# FOREST HEIGHTS ESTATES

FINAL PLAT

PCD File No. MS206

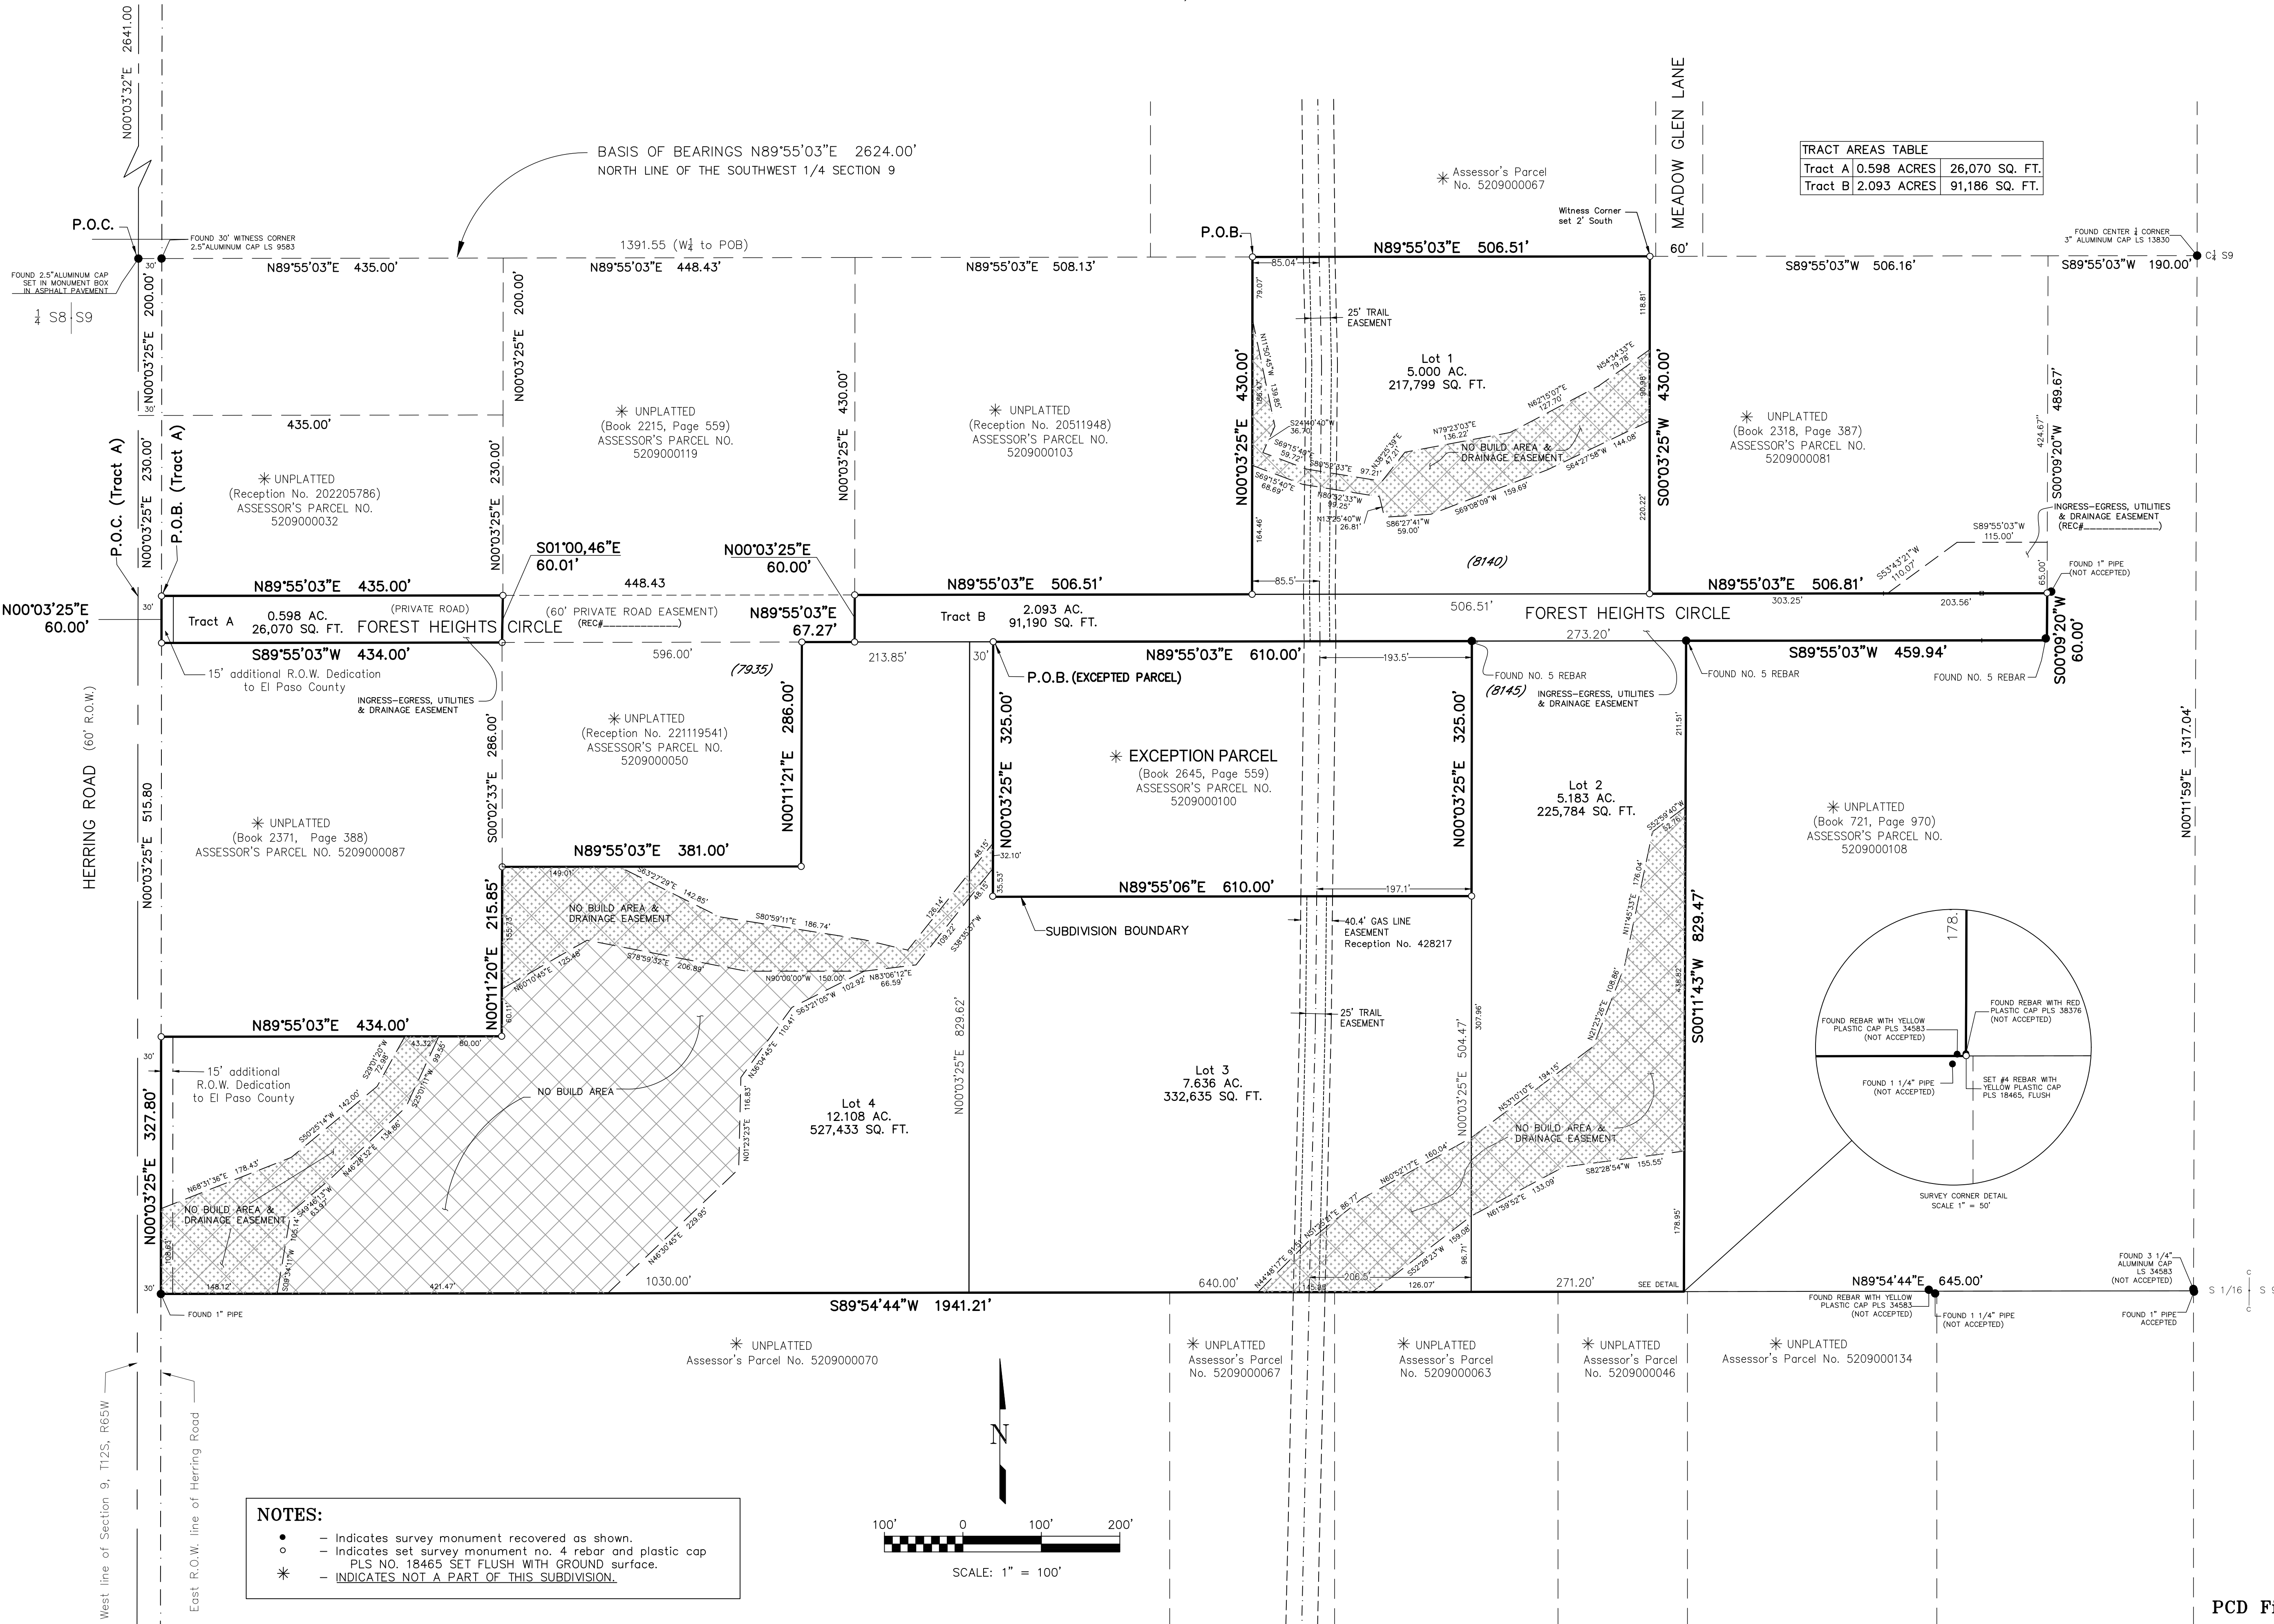
Add note:  
There shall be no direct lot access to Herring Road.

Tract B missing

Appears to be missing lot lines  
Please clarify and correct linework

Is parcel # 5209000050 being incorporated into lot #4 or becoming its own lot? Application said this parcel would be part of lot #4. Correct linework and acreage

correct if including the above parcel into lot 4

review #2: Please provide a copy of the recorded easement or shift the cul-de-sac such that it is entirely within the proposed subdivision.  
Review 3: Unresolved. Please provide a copy and/or reception# for this easement that encompasses a portion of the cul-de-sac.

Unresolved - dotschoenheit  
10/30/2023 3:18:31 PM
